**MACQUARIE UNIVERSITY
NEW UNIVERSITY OFFICE & LABORATORY BUILDING (SSD 9313)
8-12 UNIVERSITY AVENUE, MACQUARIE UNIVERSITY**

RESPONSE TO DPIE KEY ISSUES AND AGENCY AND COUNCIL SUBMISSIONS

Department of Planning, Industry & Environment Key Issues

Figure 15 Proposed road network changes

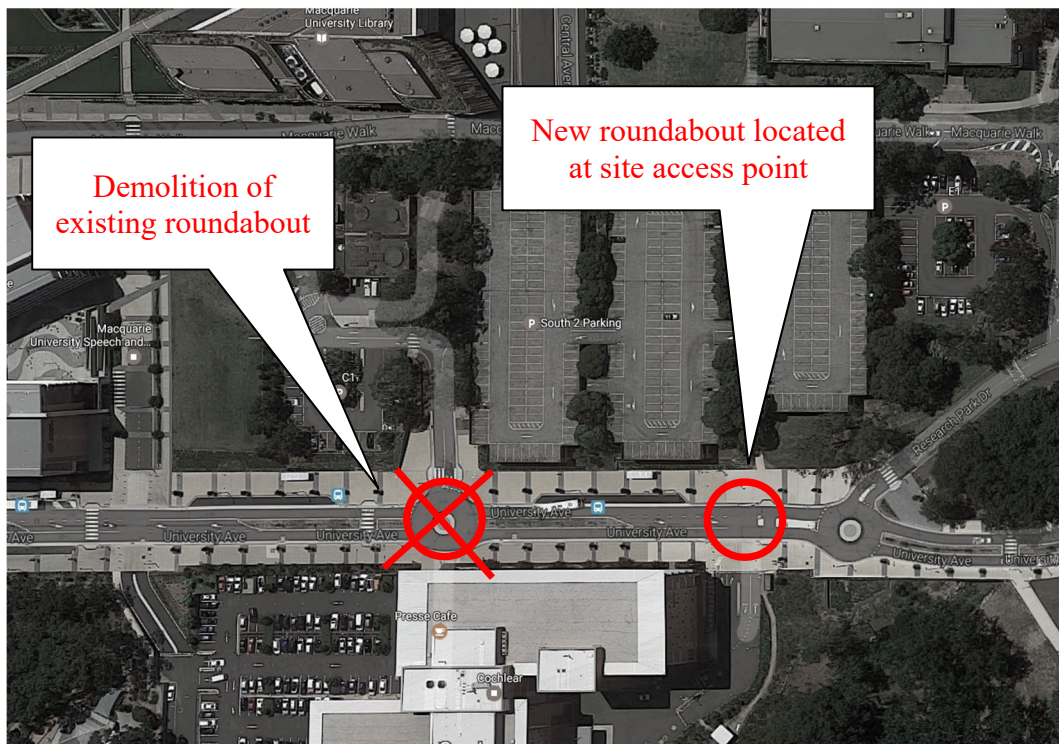
Documentation consistency	
<p>Comment: Section 4.5 of the Transport Assessment report indicates that cars enter the basement car park via the existing roundabout on University Avenue at the eastern end of the site. However, in Section 5.3 and Figure 15 of the report, it is indicated that a new roundabout would be provided at the site access point at the eastern end of the site whereas there is no indication of changes would be made to the existing roundabout where University Avenue and Research Park Drive meet. This information is not consistent with that shown in the DA drawings.</p> <p>Recommendation: It is requested that the above be clarified and documentation revised as necessary.</p>	<p>Section 4.5 and Figure 13 as well as Section 5.3 and Figure 14 of the revised traffic assessment notes that service vehicles will enter the basement car park at the western end of the site via an existing and currently active access road. Cars entering the basement car park at its eastern end will access the site via a new roundabout on University Avenue, directly opposite the existing driveway access to the Cochlear Building. The two existing roundabouts on University Avenue would be removed to accommodate the new roundabout servicing the eastern edge of the site.</p>
